## **Helios Renewable Energy Project**

**EN010140**

### **Burn Gliding Club IP 20050600**

Response to:

Drawing Title:  
**Cumulative Schemes Plan**

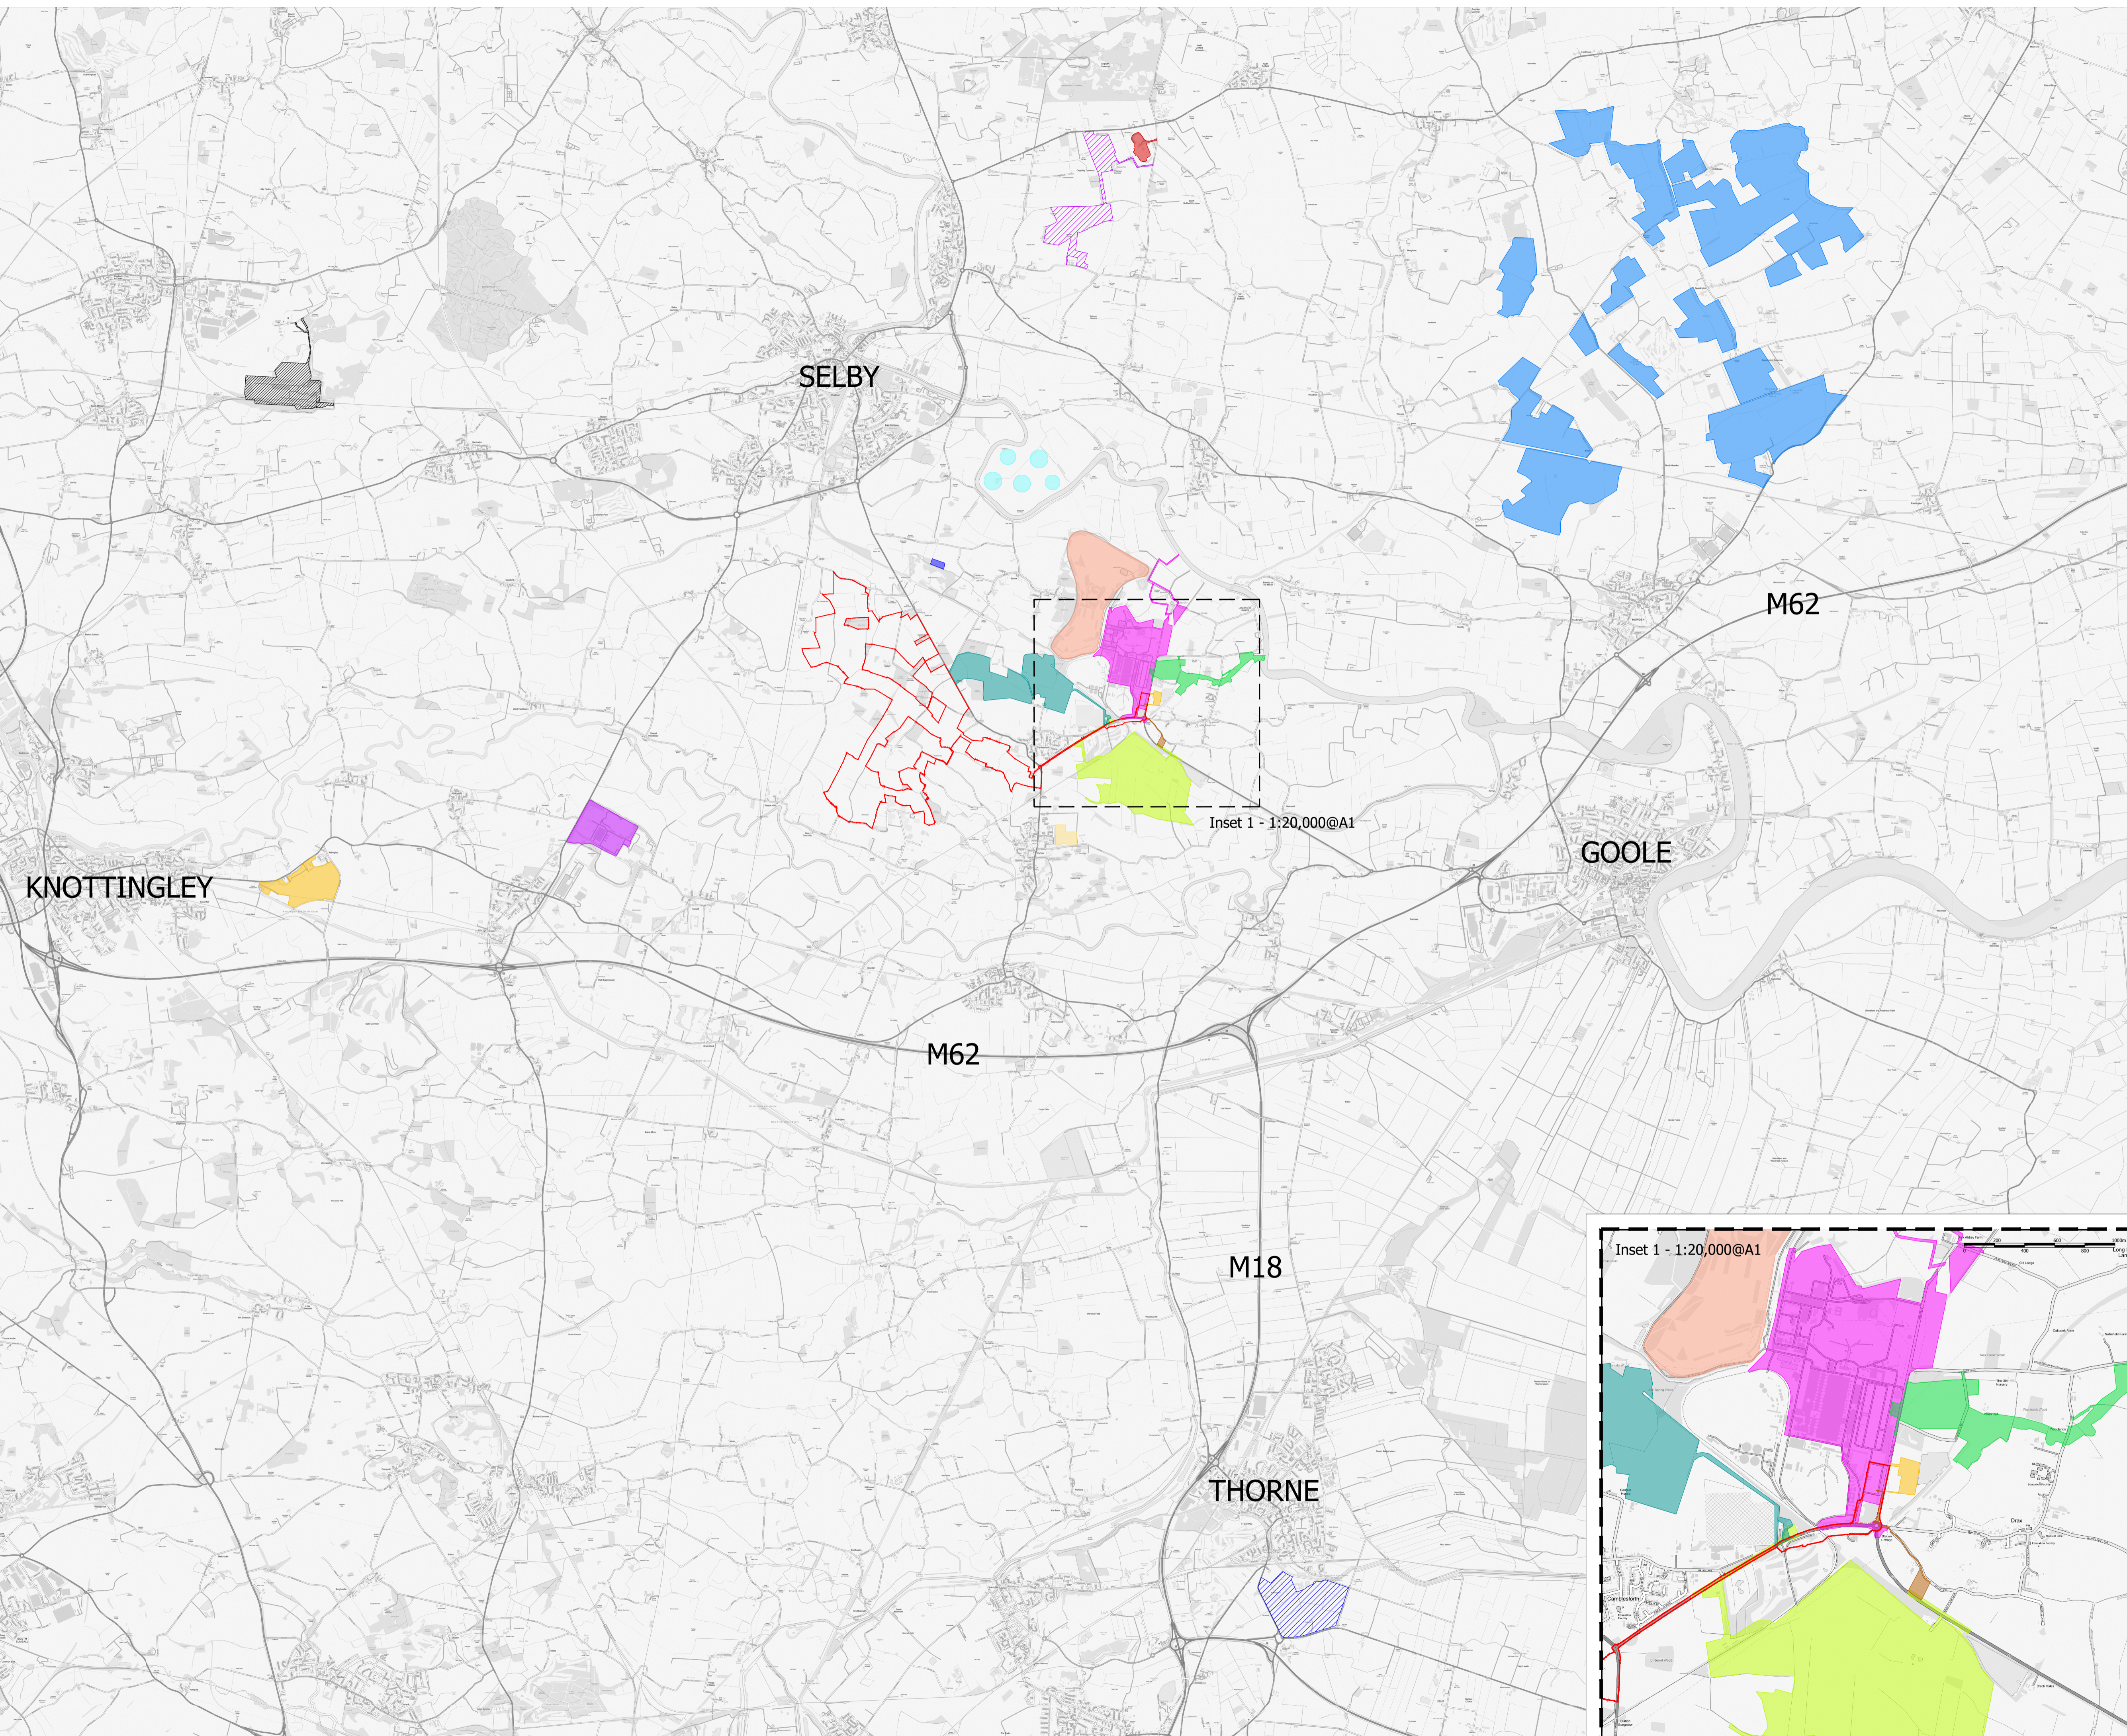
It should be noted that, to date, only the Helios project has been addressed in this initial assessment of potential impacts on aviation safety. Pager Power has not examined the potential cumulative impacts on gliding activity arising from approved solar schemes in combination with the Helios project.

One solar farm may have limited glare impact, but several in proximity can create overlapping periods of glare, increasing the risk of temporary visual impairment for pilots.

The proximity of several solar energy generation sites near different parts of the airfield or along various flight paths, may generate a cumulative glare risk which could cover multiple critical phases of a flight (i.e. approach, departure, circuit patterns).

Persistent effects: The combination of reflections from several sites may extend the duration and intensity of glare events throughout the day/year.

While individual solar energy generation sites can introduce mitigation (for example anti-glare coating or buffer zones), multiple projects may overwhelm mitigation measures, making cumulative management impractical or less effective.
